**Our Case Number:** ABP-314724-22

**Re:** Railway (Metrolink - Estuary to Charlemont via Dublin Airport) Order [2022]  
Metrolink. Estuary through Swords, Dublin Airport, Ballymun, Glasnevin and City Centre to Charlemont, Co. Dublin

## **RE: MetroLink Railway Order (Case: 314724)**

## Tara Section

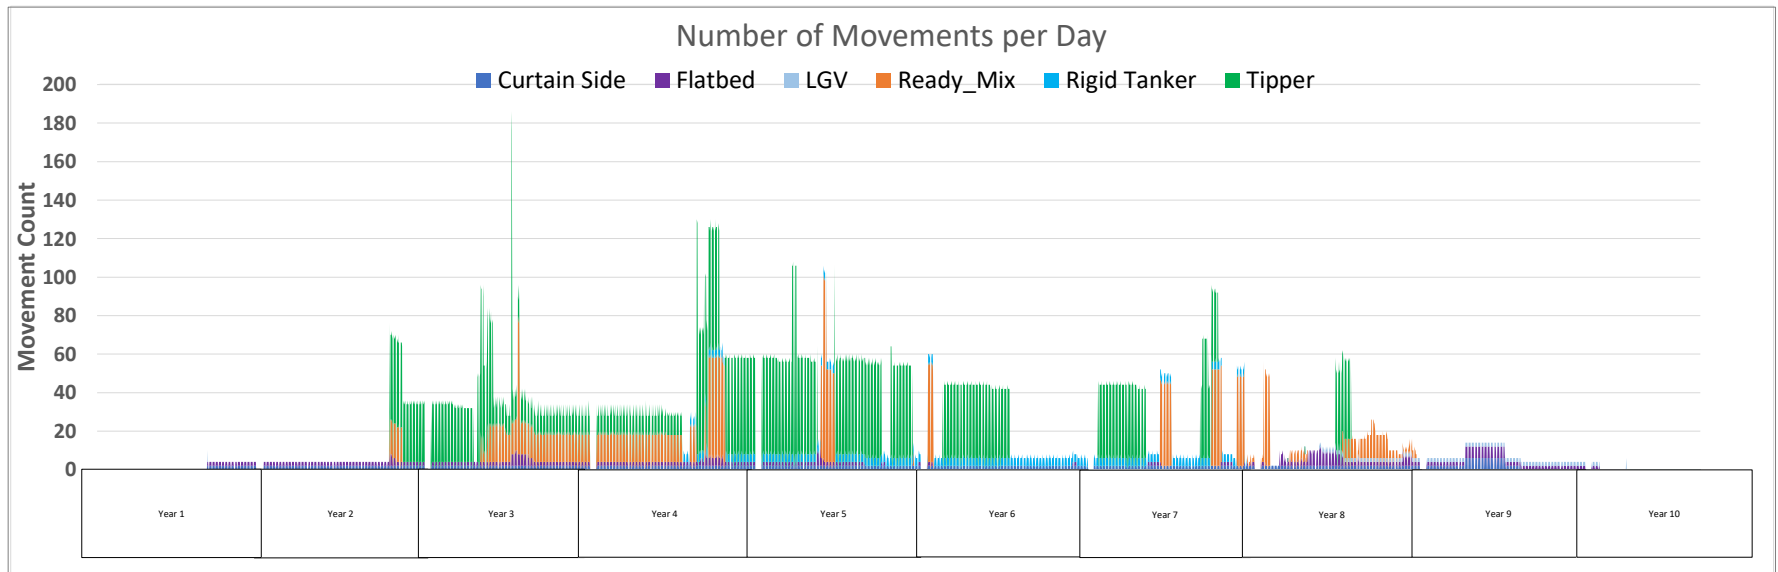
Our biggest concern is at Tara Street station. Again the applicant argues there is not enough space to provide the necessary cycle parking. The applicant is CPO'ing the whole block so adjacent land is within their control. The vast majority of the site post-construction is marked for "future development by others". TII could use that space for cycle parking in the interim. TII could condition the future development land to include cycle parking for the metro and train station within the new development.

TII makes unfounded arguments that shared bike schemes will lessen the need for cycle parking at stations like Tara Street. Even still, their proposals include removing the existing Dublin Bikes station outside of the Constant Markiewicz centre for construction and not reinstate it post-construction (MetroLink Structures Tara Station Proposed Street Level Design – Sheet 1).

- At Ballymun and Northwood provide more cycle parking in adjacent land
- At Tara Street TII will own the adjacent land and could use it to provide the cycle parking they are required to provide. Reinstate Dublin Bike stations near the station
- At all locations consider the use of two-tier cycle parking racks to increase densities where space is constrained
